**Addendum No. 3**

RE: Contract # C204467

**Buncombe County (I-6063)**

I-40 FROM MILE MARKER 50 TO MILE MARKER 55.

**OPTION 2 - DETAIL OF MECHANICAL SPLICE**

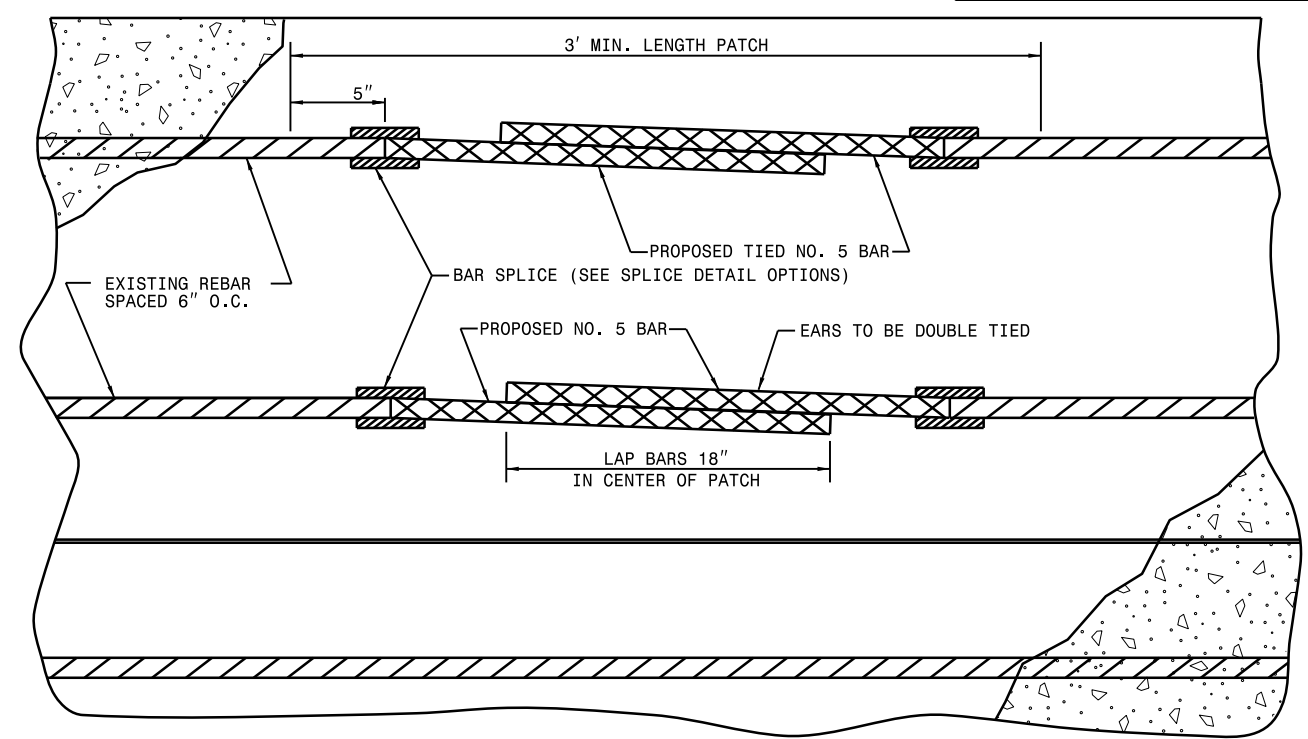
**Option 2:**

Reinforcing steel of the size shown on the plans shall be installed and spliced in accordance with the details in the plans. The reinforcing steel shall be cleaned of loose concrete, rust and other materials to the degree acceptable to the Engineer before making the splice.

The bar coupler shall be a cold forged mechanical splice applied by dies of an appropriate shape. The completed splice shall achieve 125% of the required minimum yield strength. Samples of complete splices shall be furnished to the Engineer for testing purposes. The proposed bar coupler shall be approved by the Engineer before being used. An 18" lap splice shall be provided at the center of each patch.
